From: [REDACTED]
To: [Viking CCS Pipeline](#)
Subject: FW: Rep "Have your say" Savills (Savills) on behalf of The Needham-Teanby Family (The Needham-Teanby Family) 20047081
Date: 01 May 2024 16:24:46
Attachments: [REDACTED]

Savills (Savills) on behalf of The Needham-Teanby Family (The Needham-Teanby Family) 20047081

Drawing title  
**STANDARD DETAILS  
TRENCH EXCAVATION  
Regulation 5.2 (o)  
Application Document Reference 4.17  
(Sheet 1 of 1)**

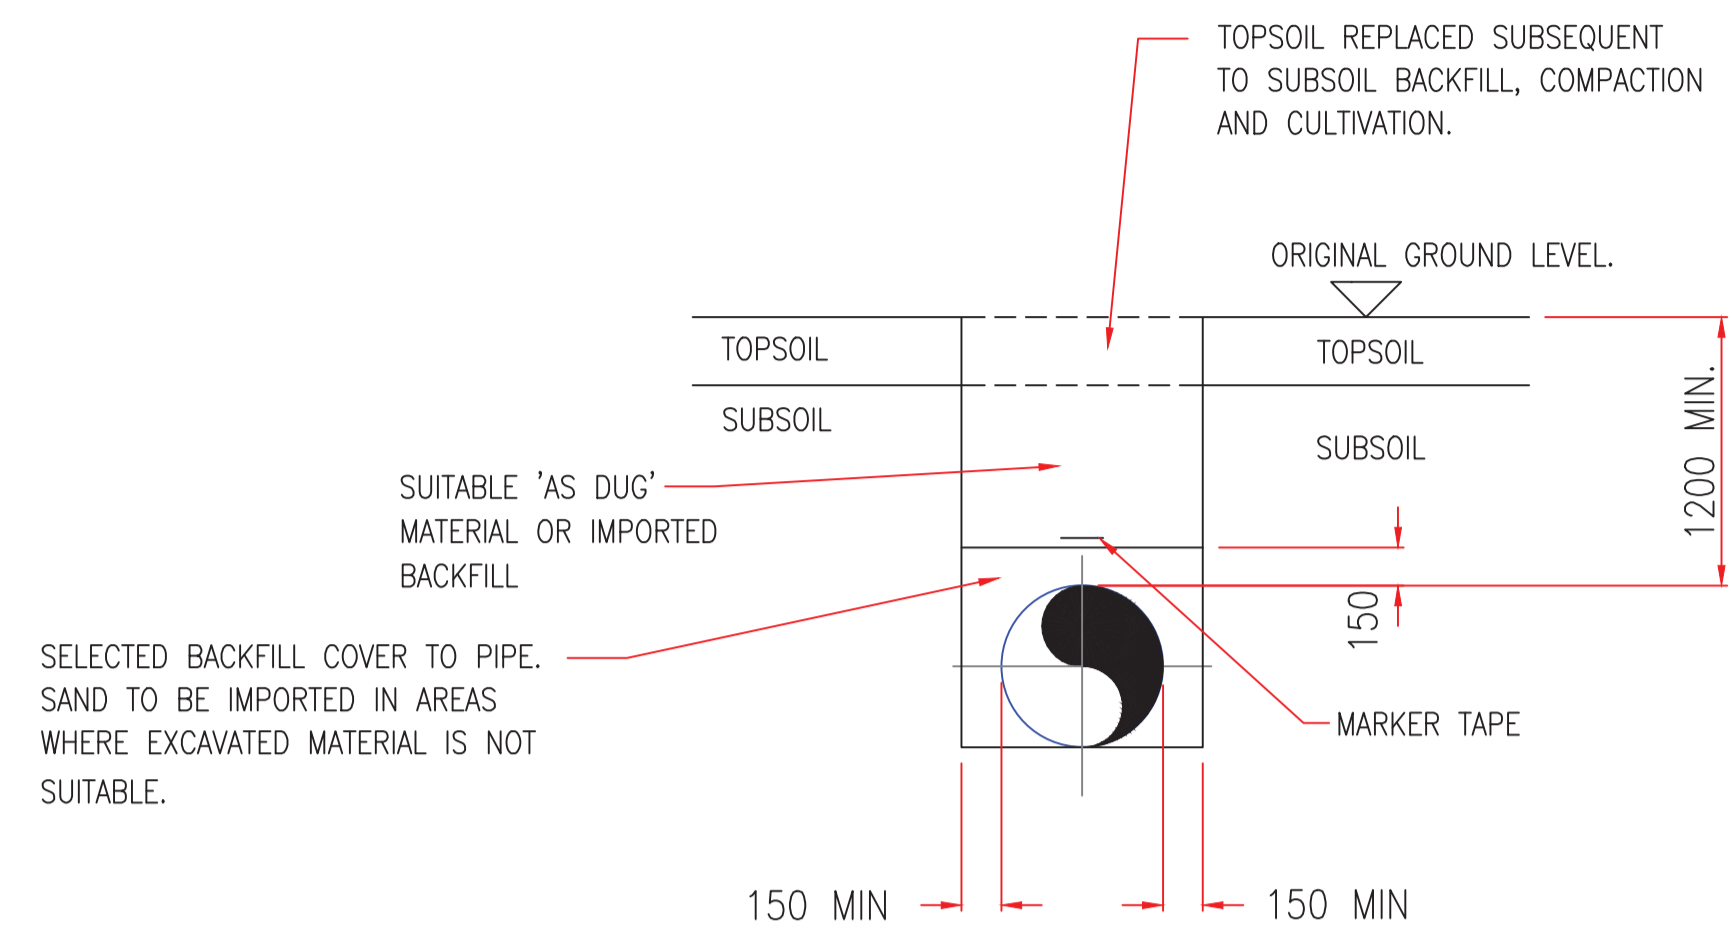
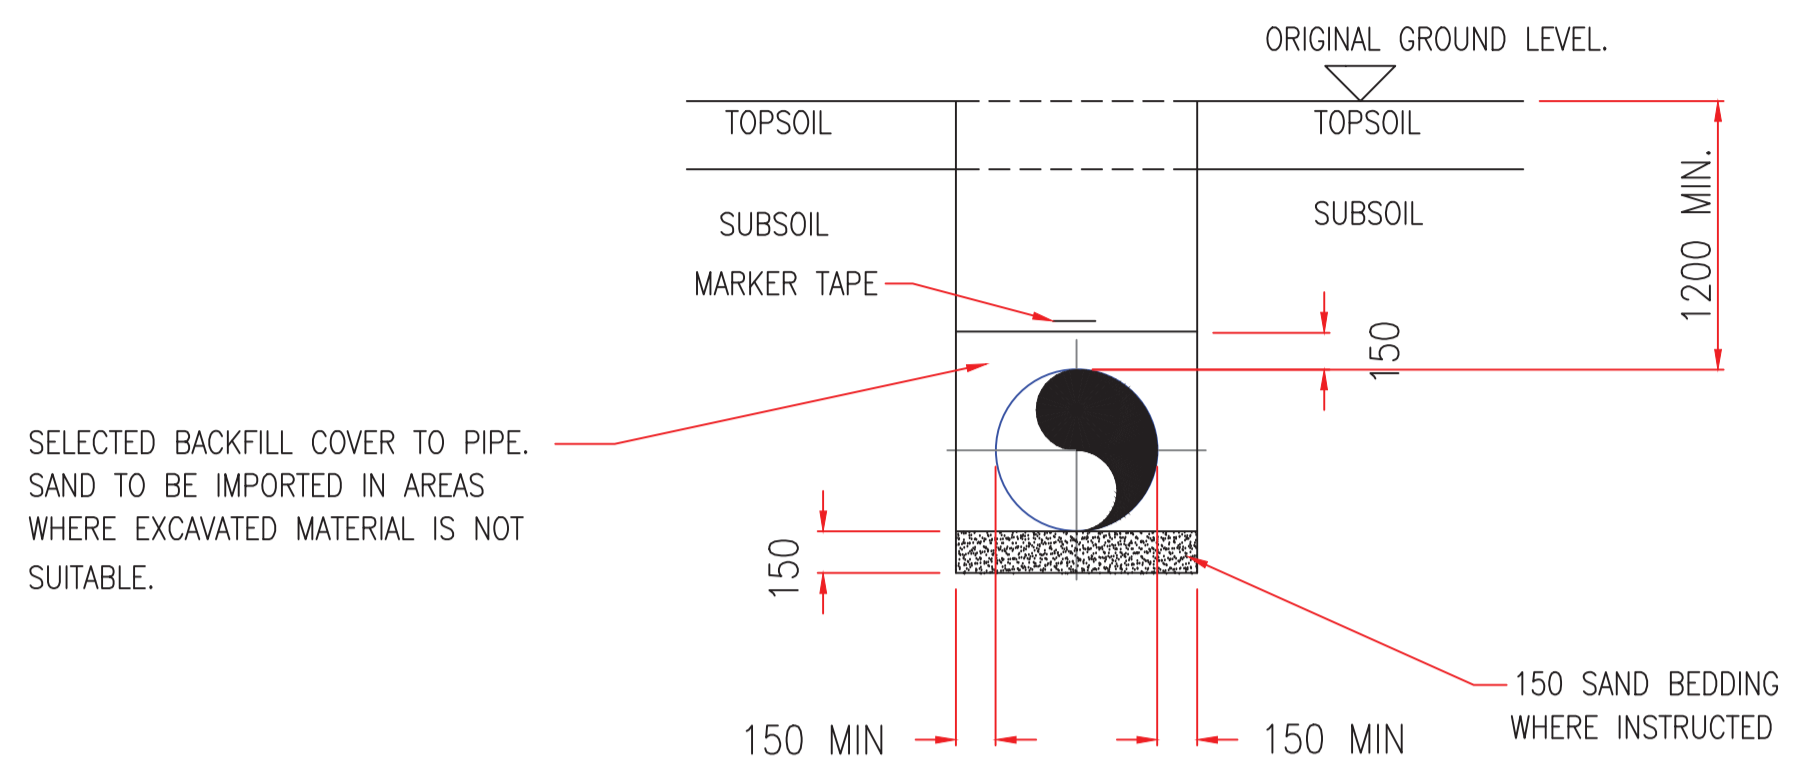
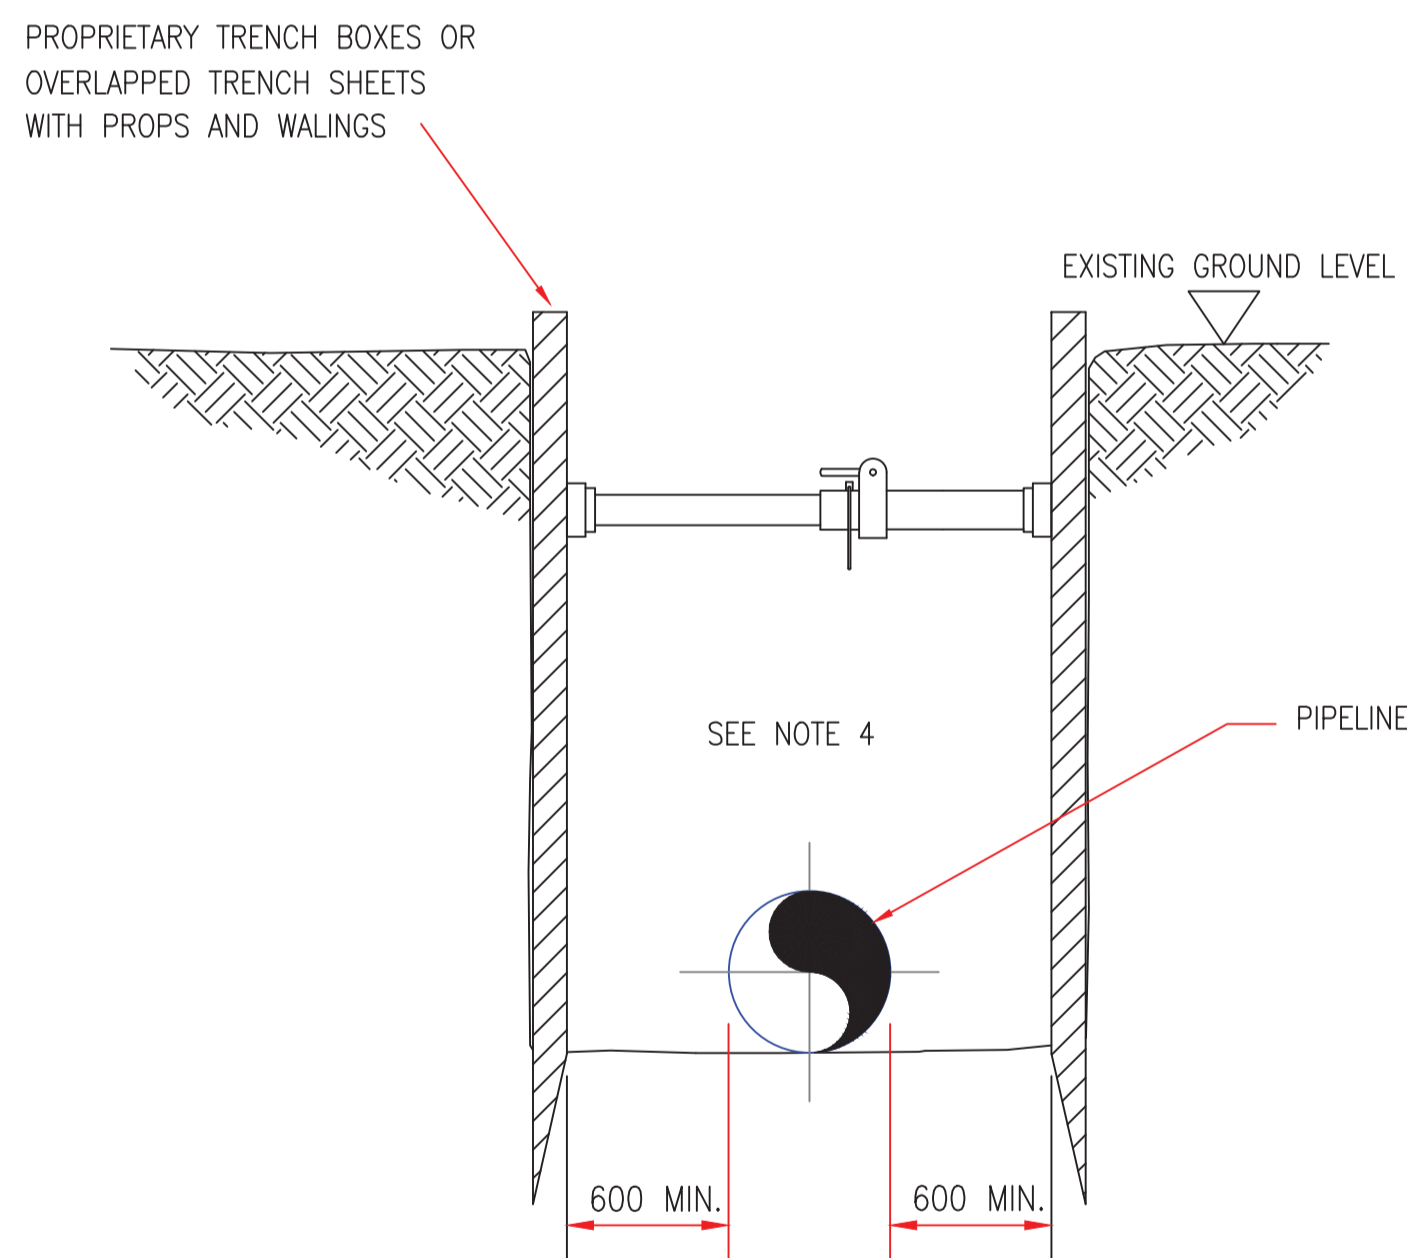
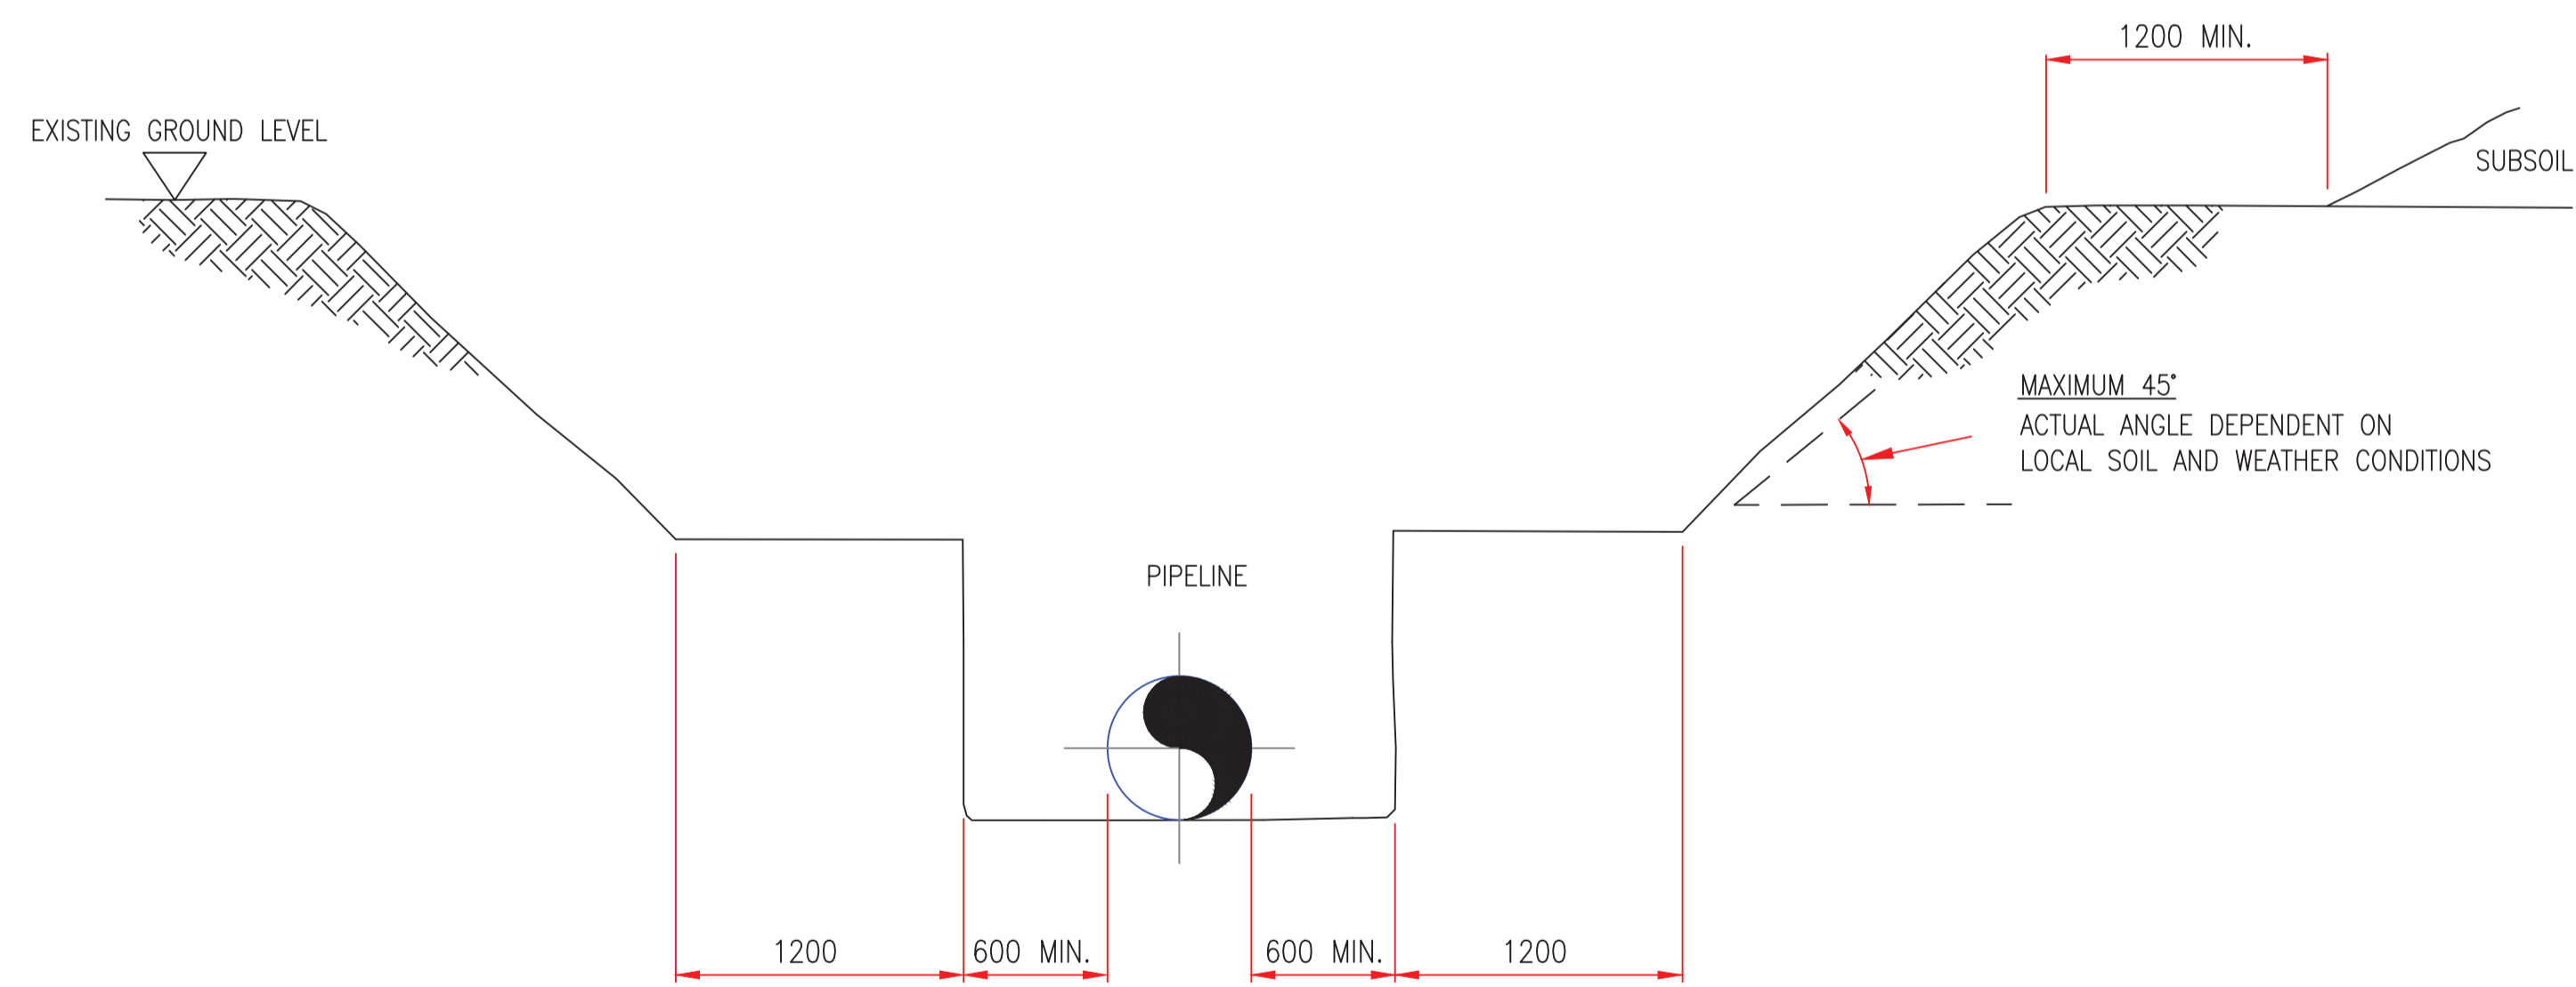
Currently the proposed lease depth (at the top of the pipe) is 70cm below the surface; my client mole plough's to 70cm, over time there is every chance that this soil cover will get less and there is not adequate headroom to enable sufficient clearance over the leased area to be maintained. At a depth of 70cm there is every possibility that my client will go into this leased area with his machinery and will be in breach of the lease. We require the lease depth to be 1.0m.

The proposed depth (at the bottom of the pipe) is 20metres below the upper limit. This appears excessive and we have not received an explanation why this depth is required. Without a clear explanation of why this depth is required we object to the depth at this level and require that the leased area only cover the depth of the constructed pipe area with a small amount of head room.
